OUT13/26249

**Cobbora Coal Project (MP 10_0001)
Comment on the Revised Preferred Project Report**

Cobbora Coal Project (MP 10_0001) Revised Preferred Project Report (PPR) Additional comment by NSW Office of Water

Water Management System Concept for Year 4

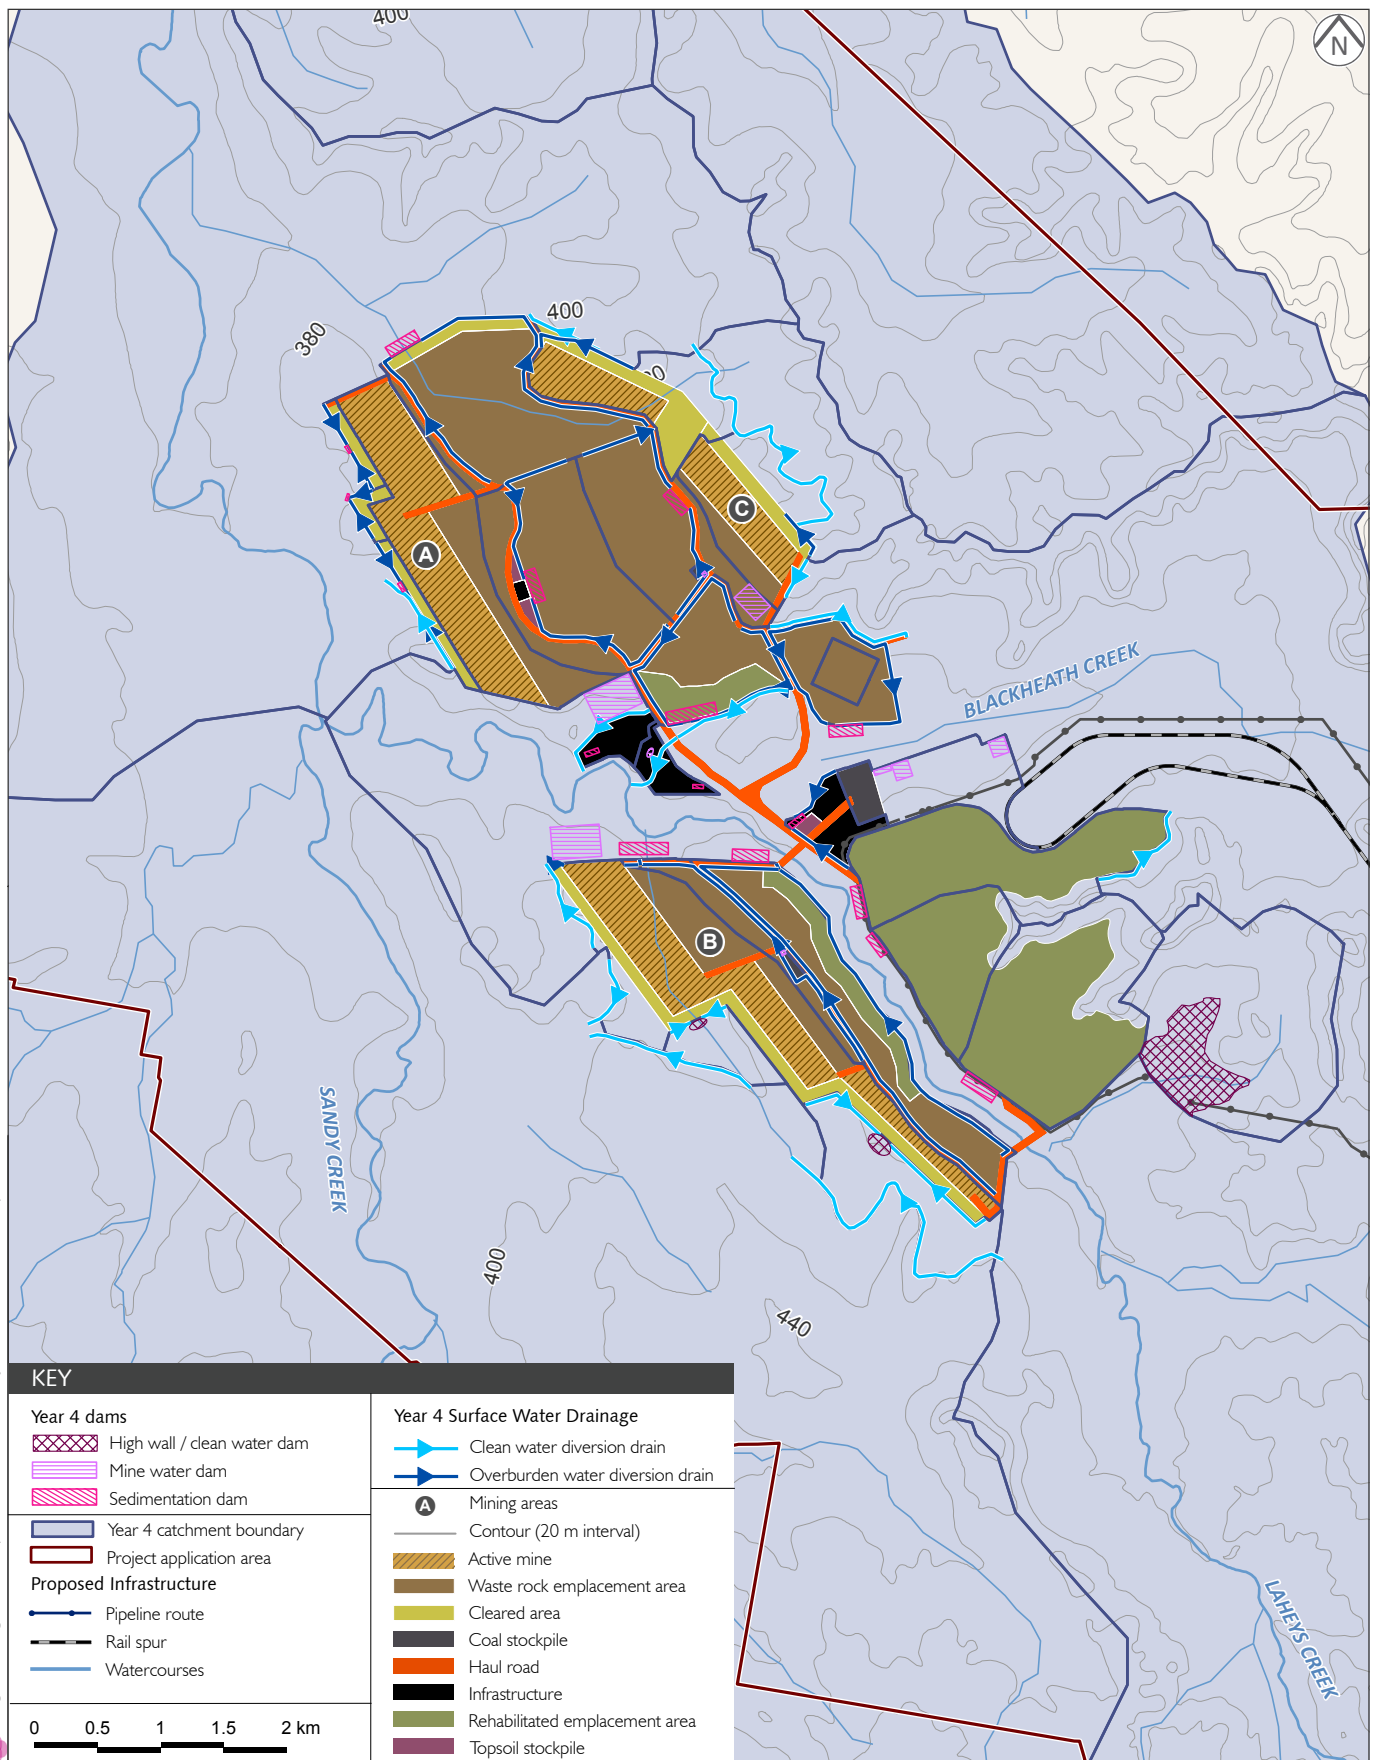
- Section 3.11.3 refers to proposed clean water diversions around the Mine Infrastructure Area and Coal Handling and Preparation Plant. A map is requested detailing the location of these drains and proposed management measures to convey water into the creek system.
- It is recognised an additional refuge pool is predicted to be impacted by drawdown and another pool would be affected earlier than the previous proposal. The NSW Office of Water supports the proposal to develop an Aquatic Monitoring Strategy and the implementation of suitable contingency measures. A comprehensive groundwater monitoring plan will provide valuable data to inform potential impacts in the surface water system and support triggers for implementation of contingency and compensatory protocols.
